Application No: FG/62/26/HH
Site Address: 1 Greenways Crescent Ferring BN12 5EF
Description of works: Proposed detached garden room.

Thank you for your internet representation made on 13th August 2026 which has been recorded as an objection with the comments as follows:

OWPC85909

PROPOSED WEST ELEVATION 1:50

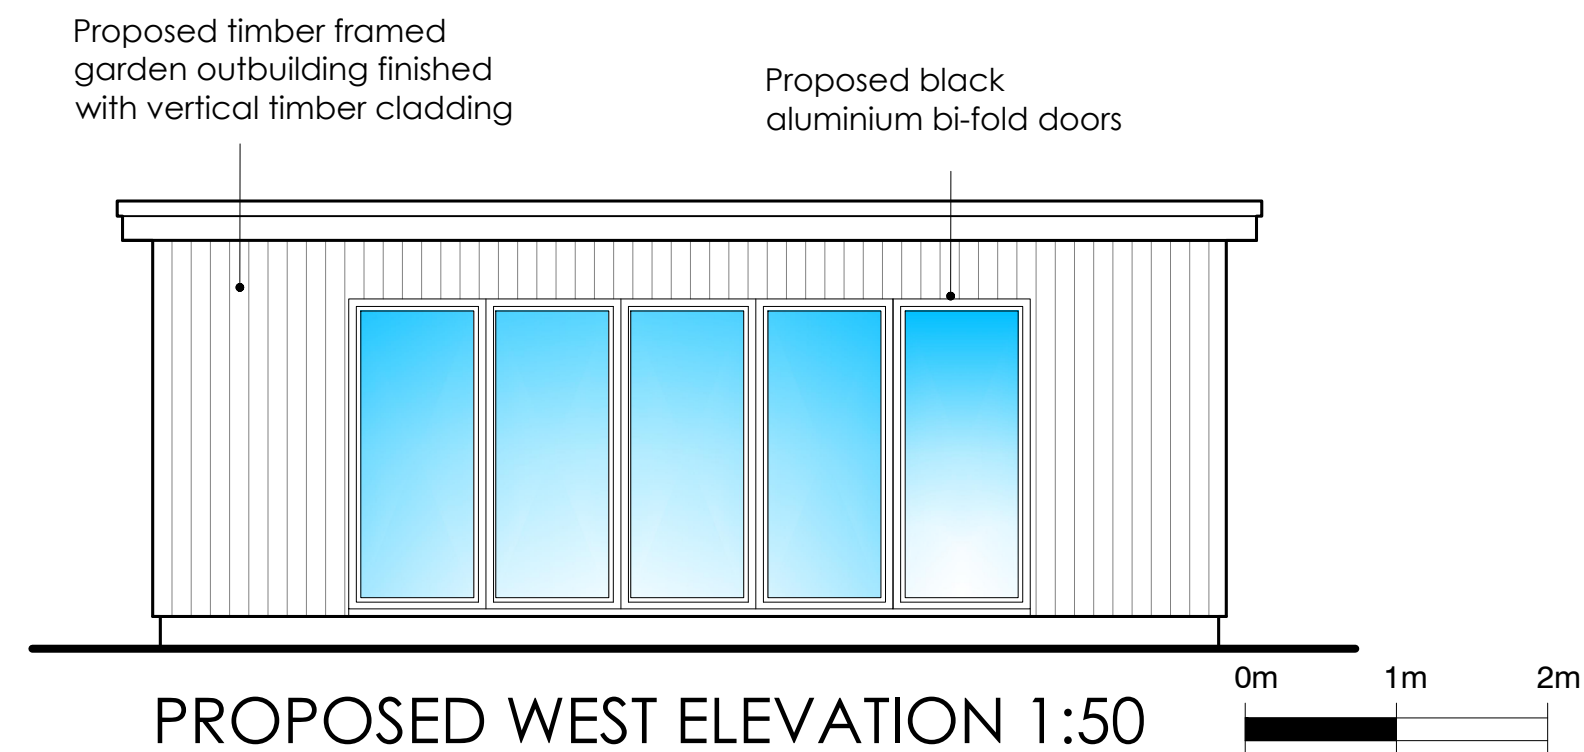
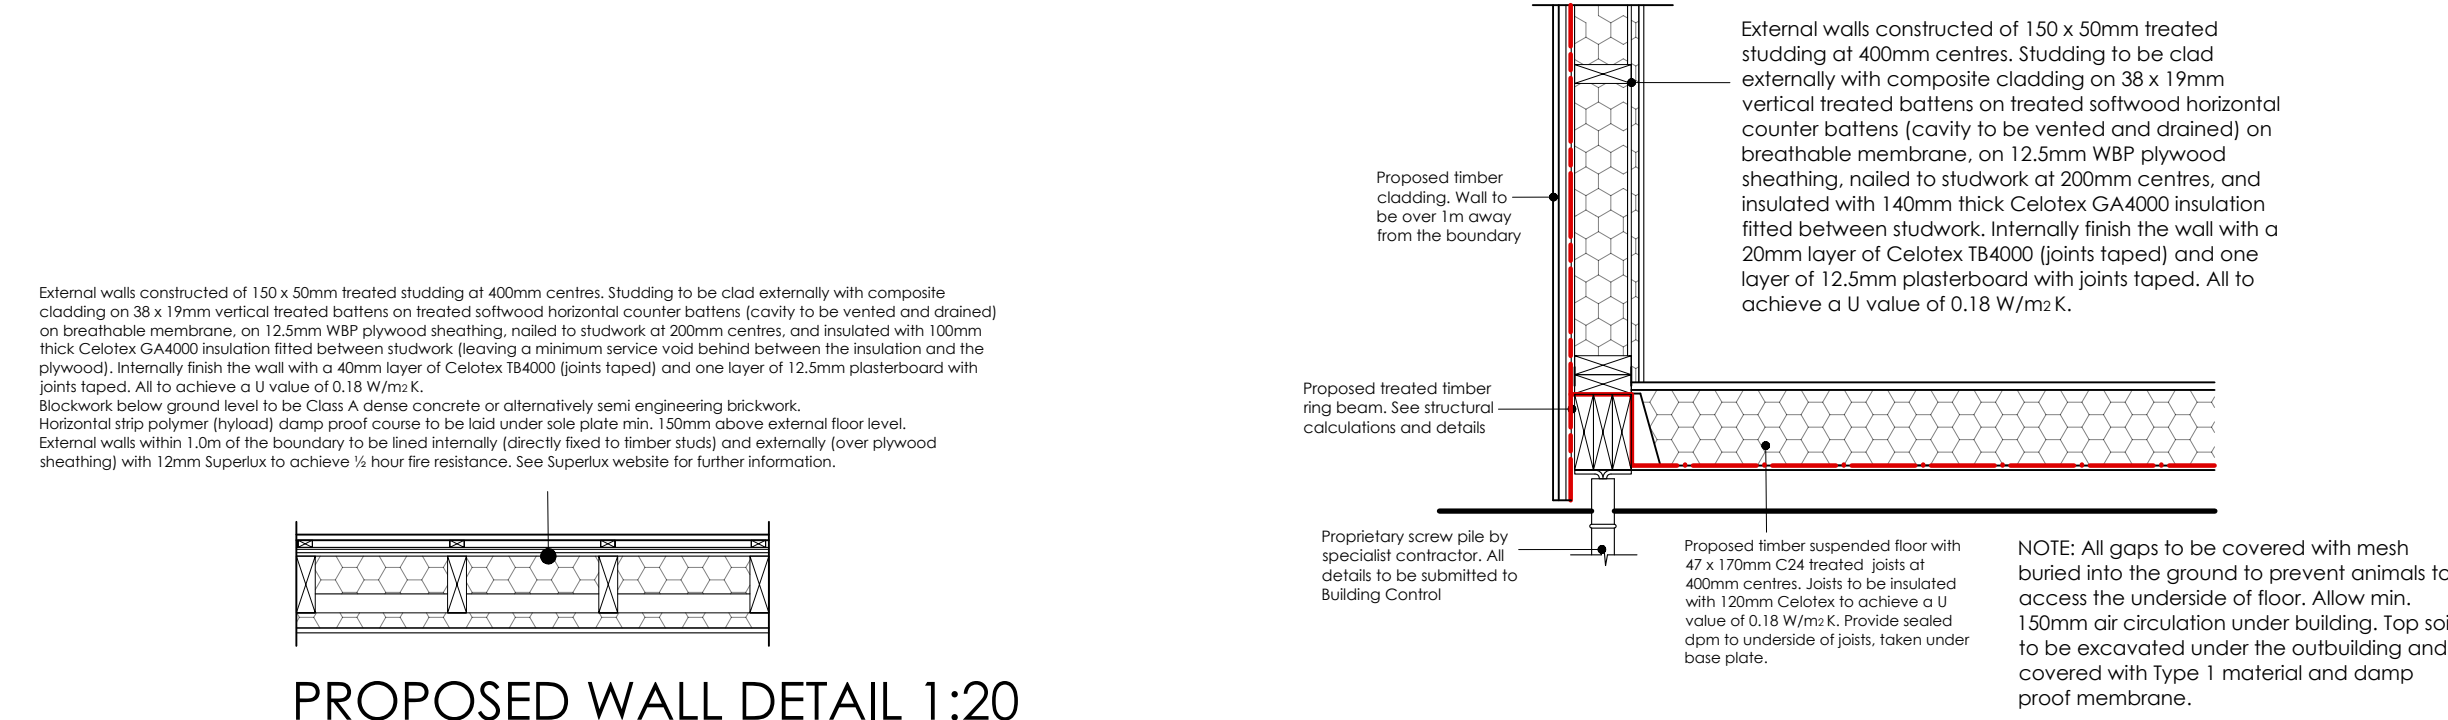
Ferring Parish Council objects to the proposed detached garden room on the grounds of its prominent position, scale and visual impact.

The proposed building is considered to be excessive in size for its location and would be unduly prominent within the garden. Due to its position and height, it would be visible from neighbouring properties and would have an adverse impact on their outlook and the visual amenity of the surrounding area.

The development would also be harmful to the character of the street scene, as the scale and appearance of the proposed garden room would not be in keeping with the established character and appearance of the surrounding properties.

For these reasons, Ferring Parish Council considers that the proposal would have an unacceptable visual impact and would be contrary to the character of the area. The application should therefore be refused.
